Job ID: 2012-10-5166-FAFS  
install supervised fire alarm system

For installation at:  
561 FOREST AVE

**This permit is to install the fire alarm infrastructure only. Additional fire alarm permit(s) shall be required for the tenant fit up(s).**

1 SECOND FLOOR PLAN
A1.2 SCALE: 1/4" = 1'-0"

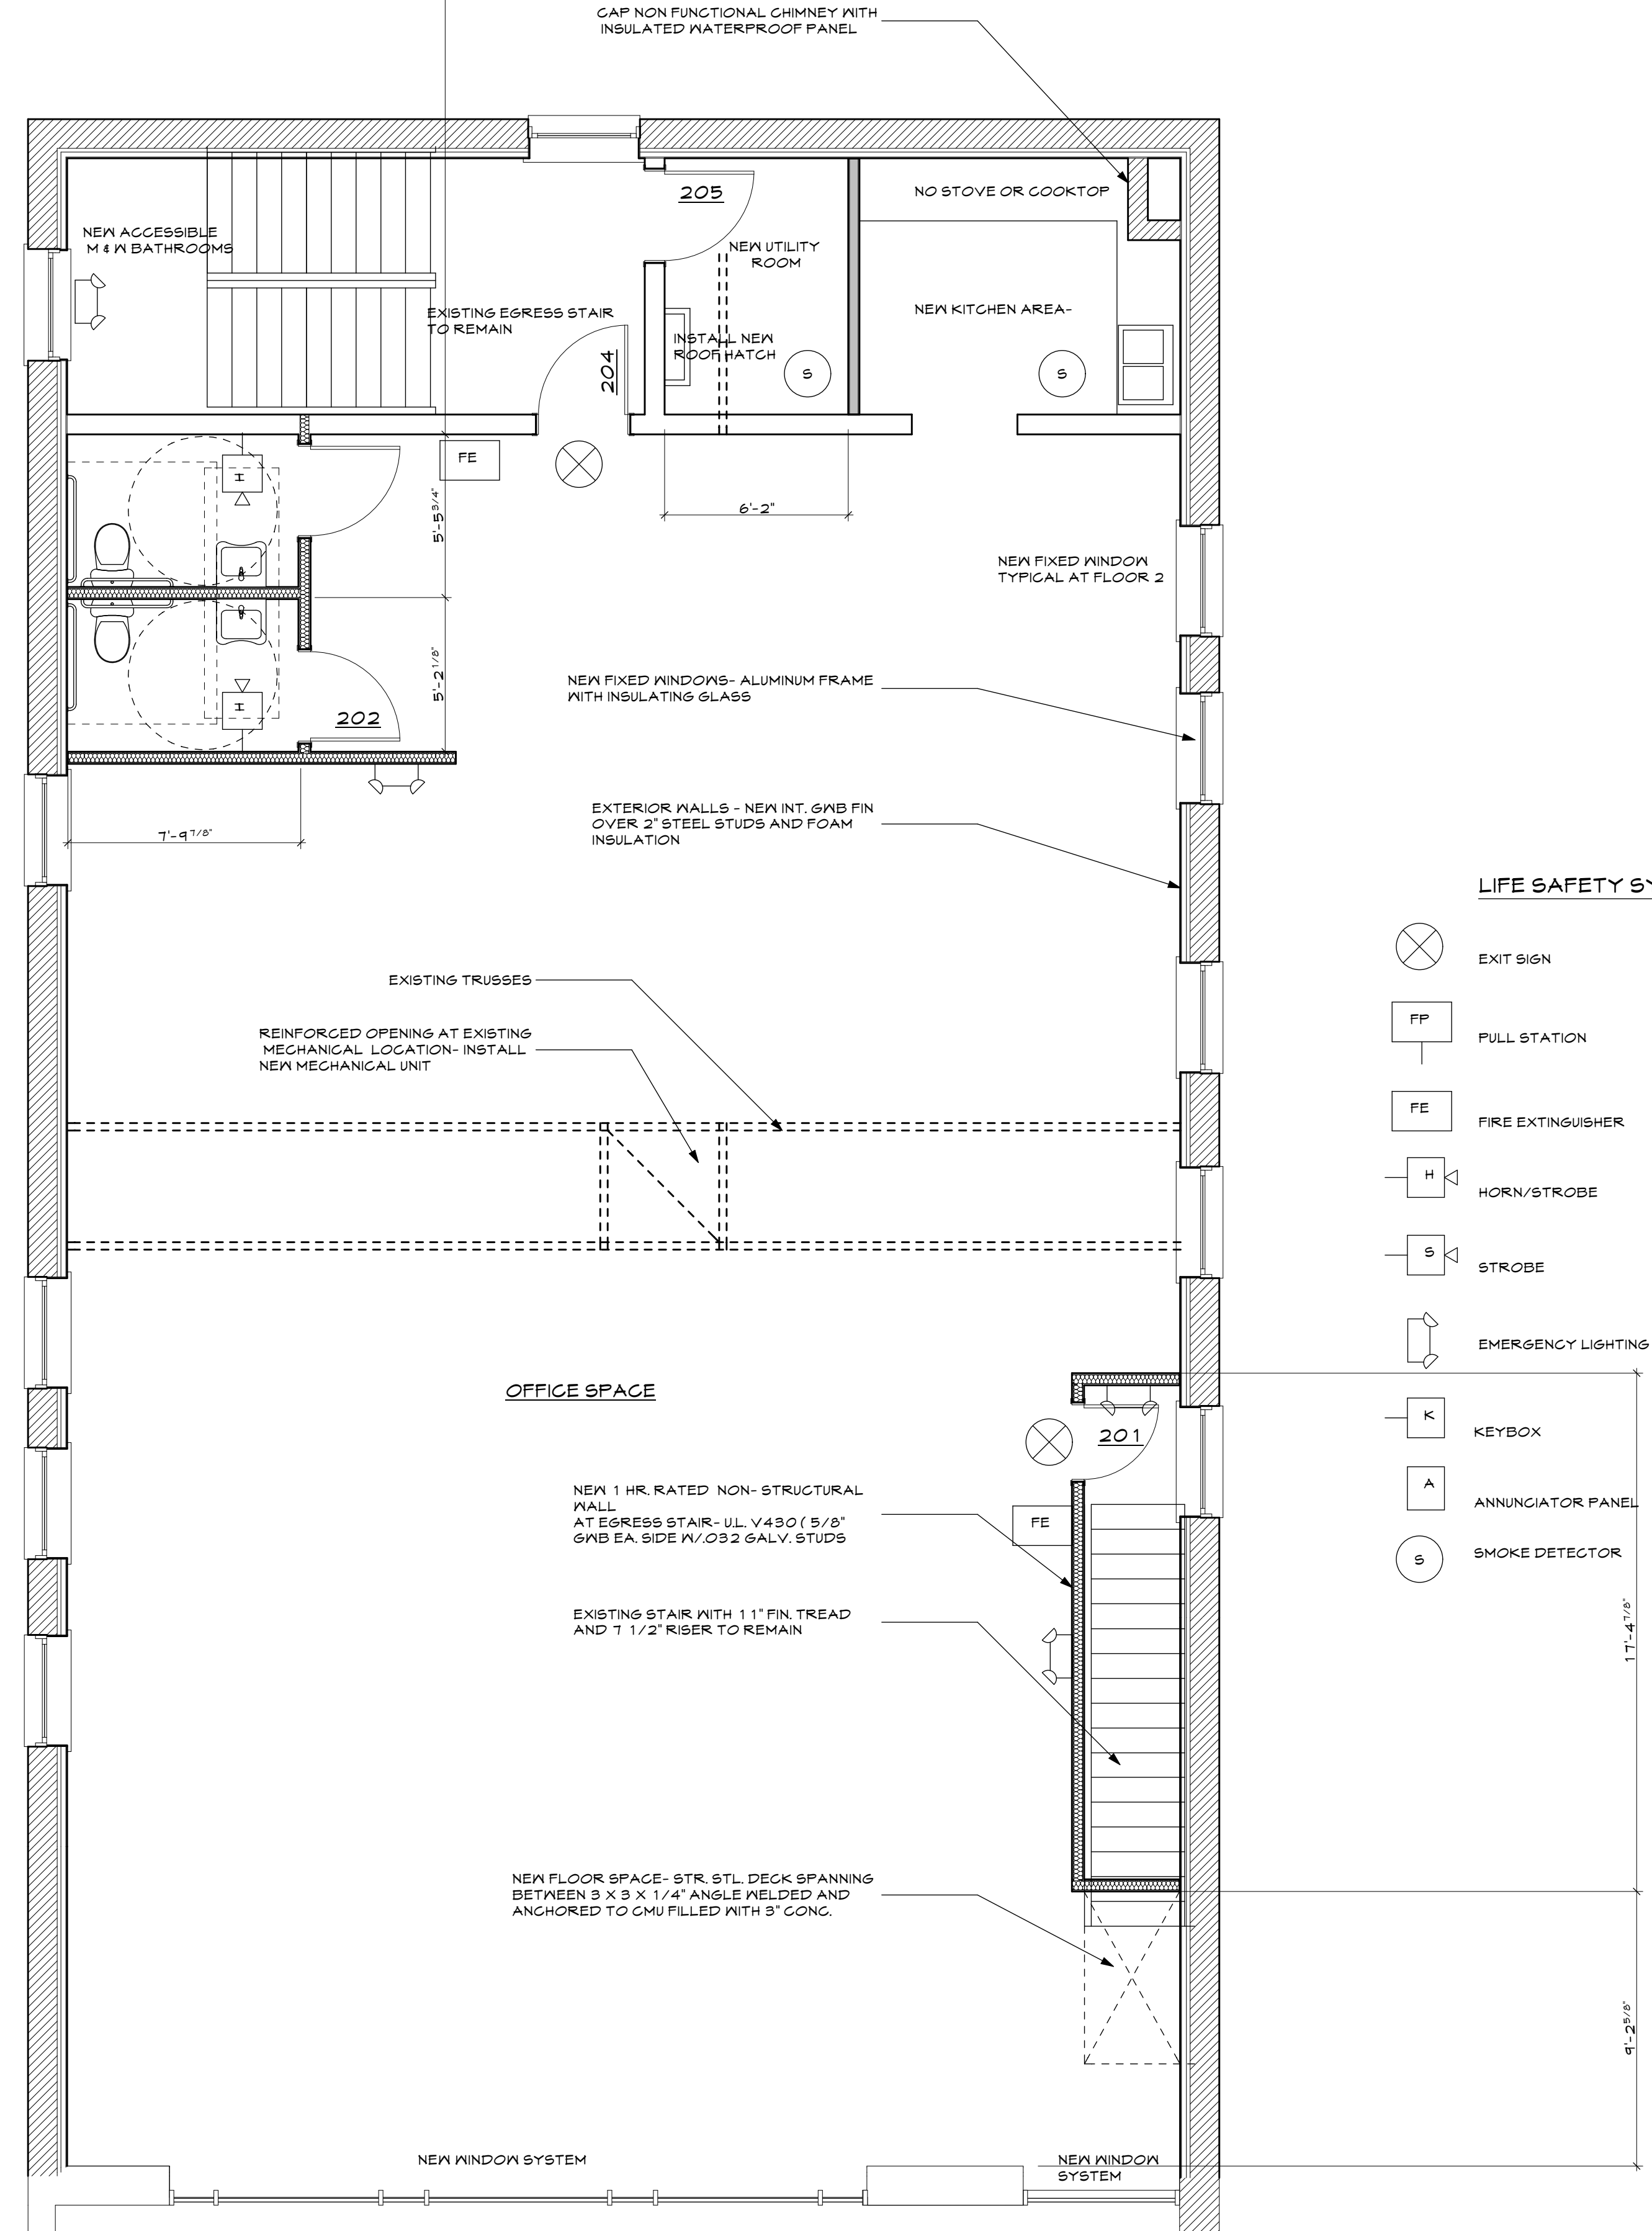
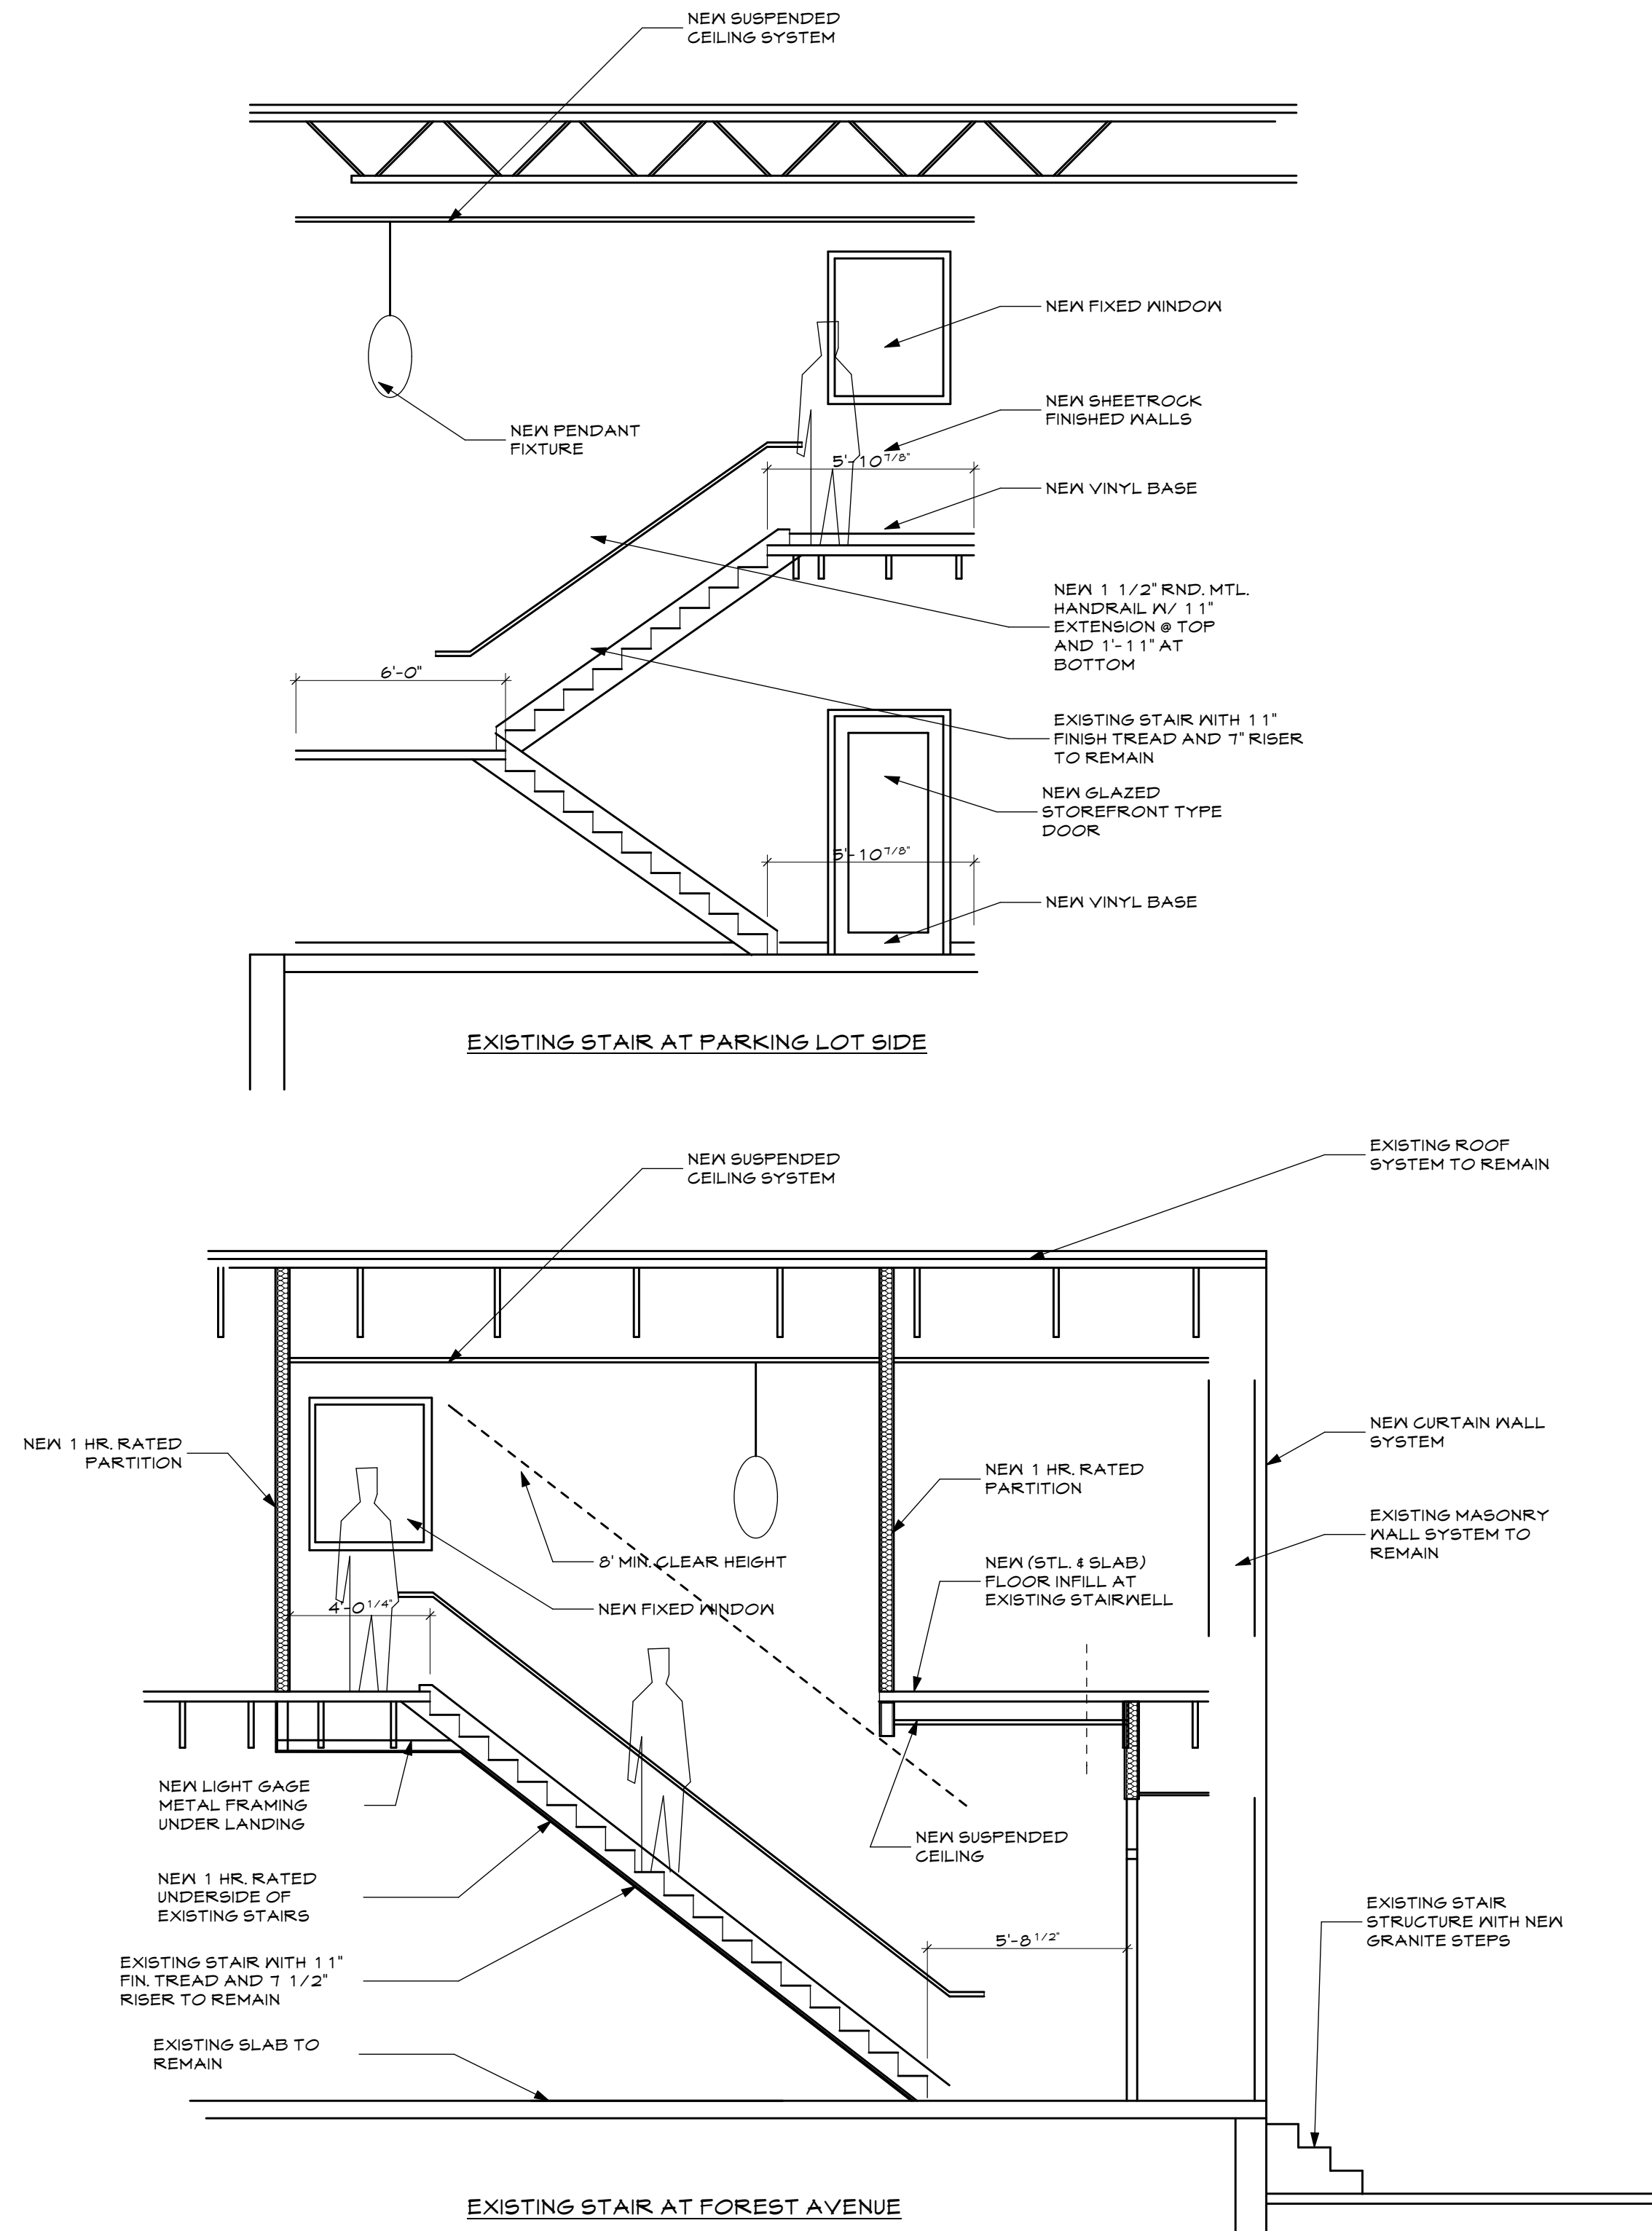
**The annunciator shall be located at the front door facing Forest Ave with a pull station. The pull station for the front stair shall be located on the second floor inside and adjacent to the stair door, not the first floor landing. There shall be no smoke detectors installed in the second floor utility room or kitchen.**
